West Midlands Interchange NSIP – TR050005 - Examination

Natural England responses to Examining Authority’s first batch of questions (ref Rule 8 letter dated 4.3.19)

Figure Title
A1.1 Lighting Mitigation

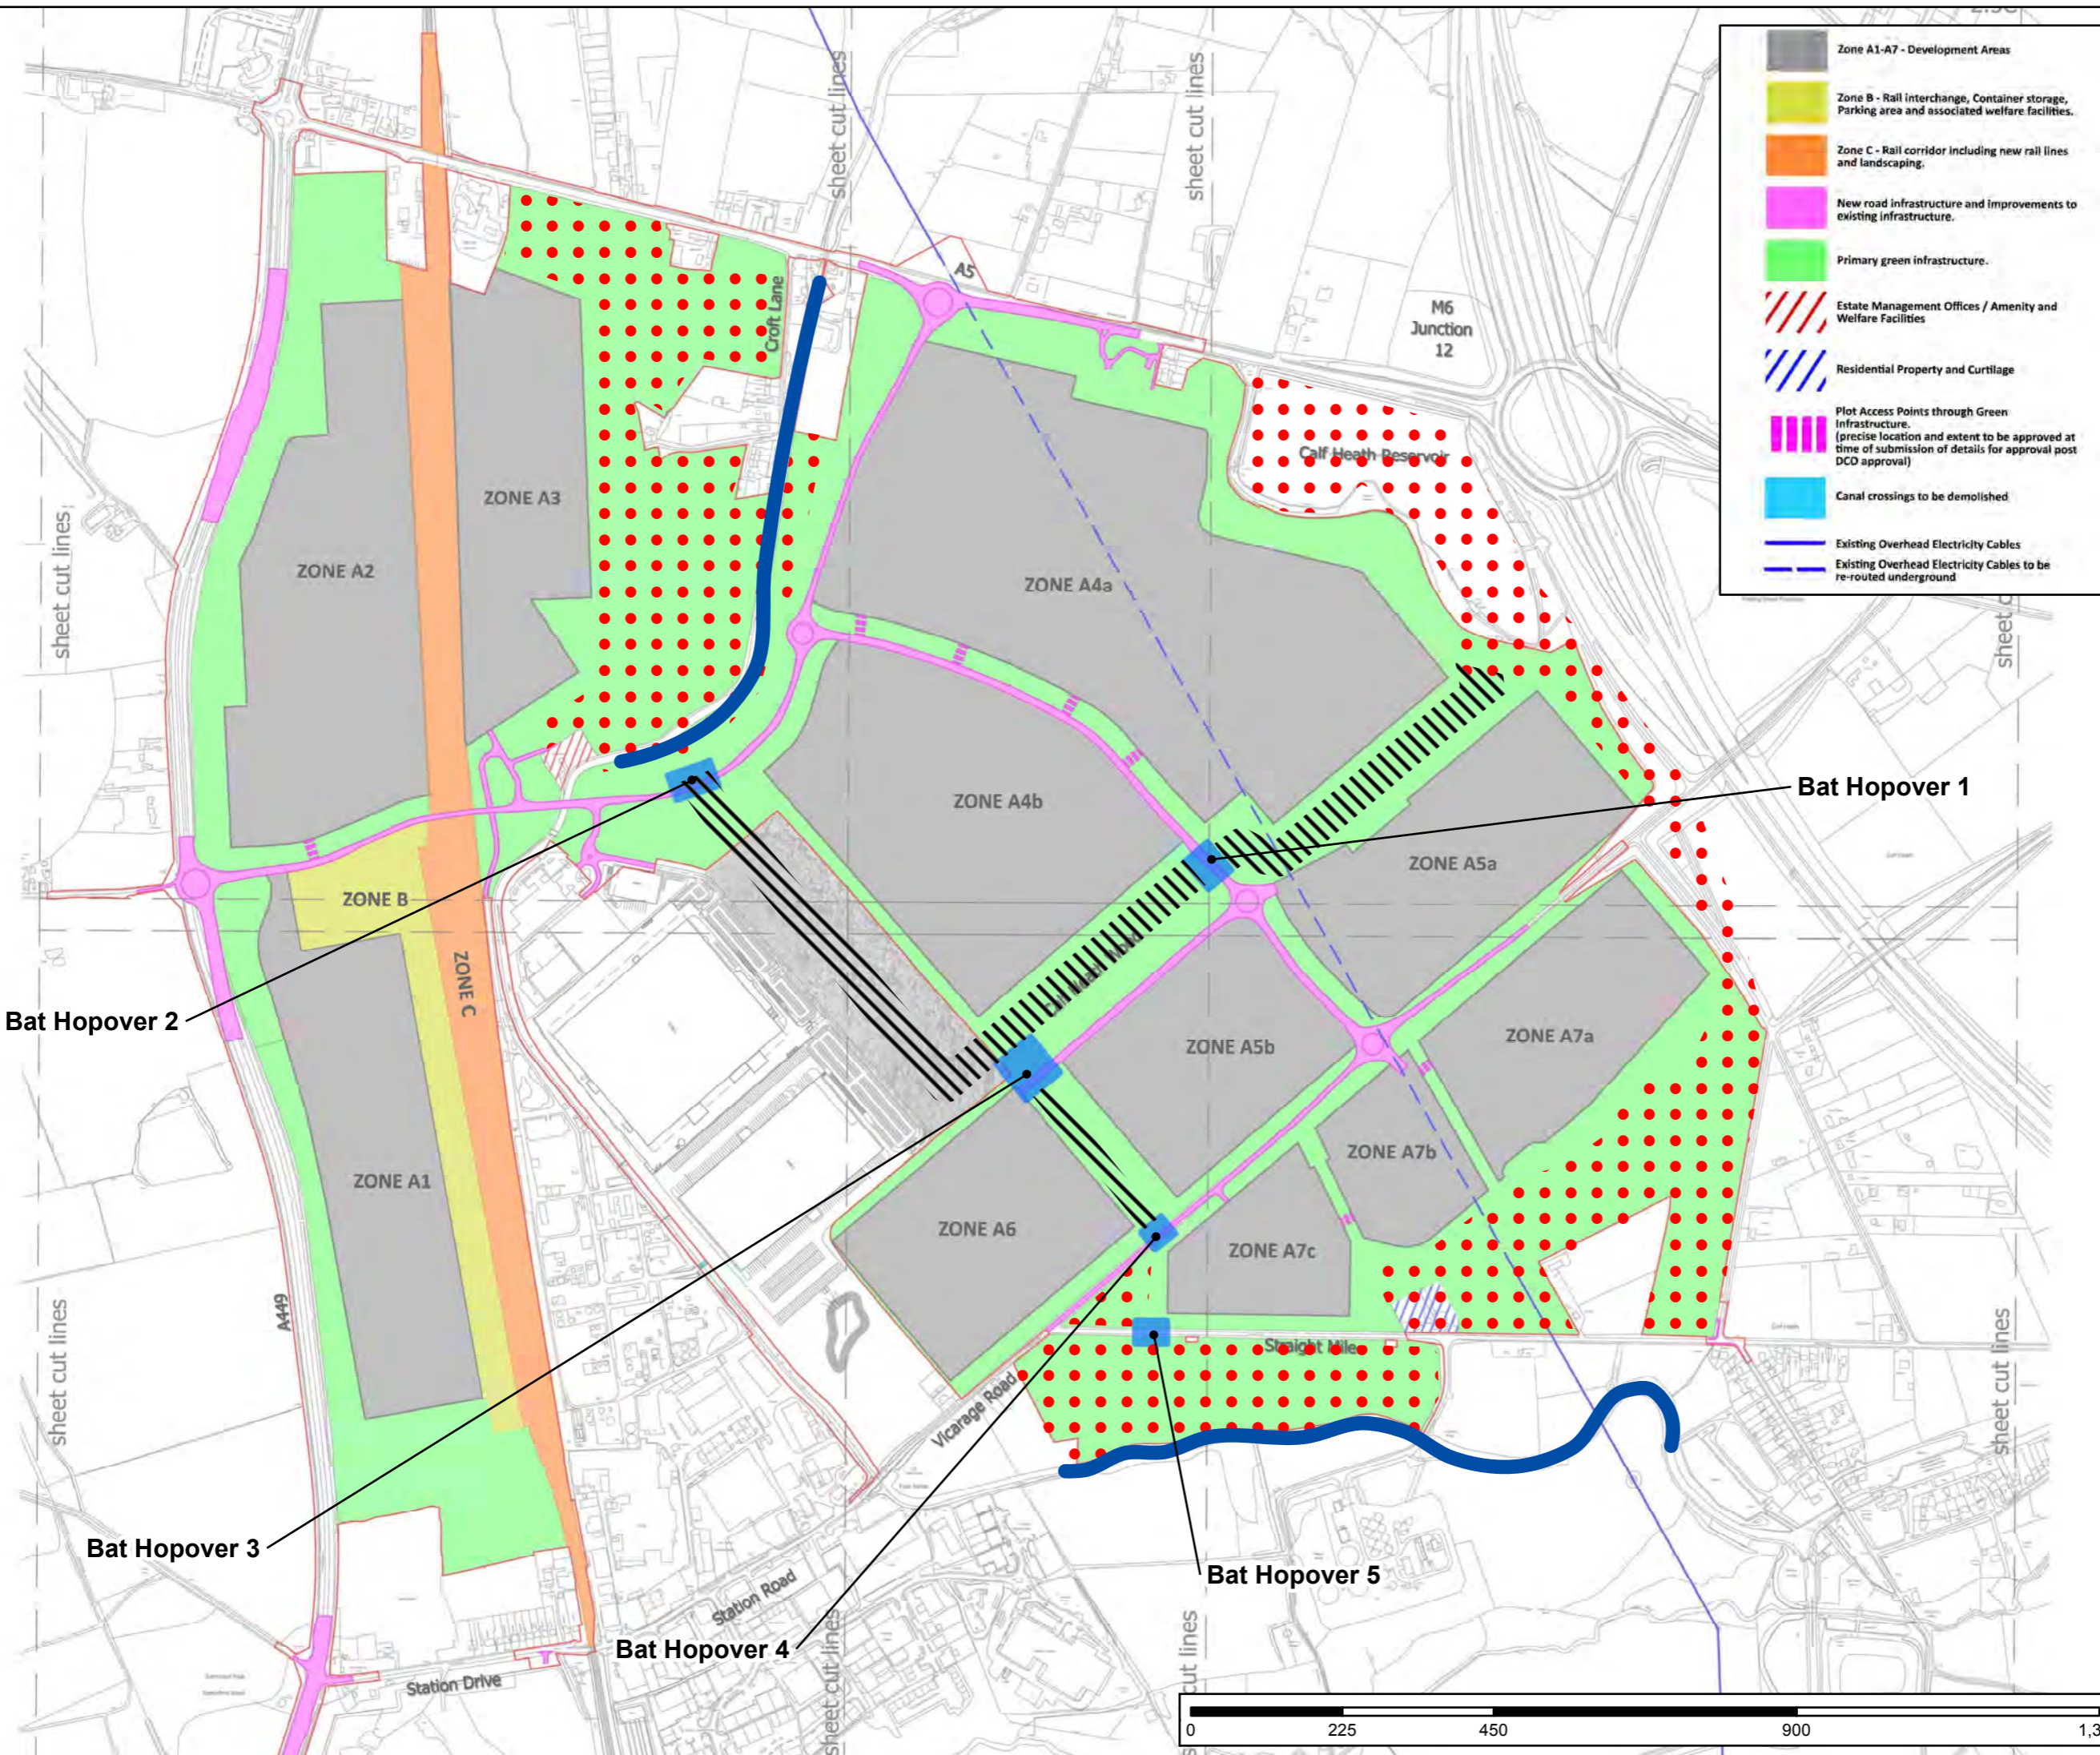
1.10.25. The Applicant, NE and SCC	Are the relevant consultees satisfied that dark corridors can be maintained in the locations shown on Figure A1.1 of the FEMMP, given that the Illustrative Masterplan [APP-206A-D] shows that these are likely to be immediately adjacent to buildings, car parks and service areas?	Please see our response to Q 1.10.24 above.
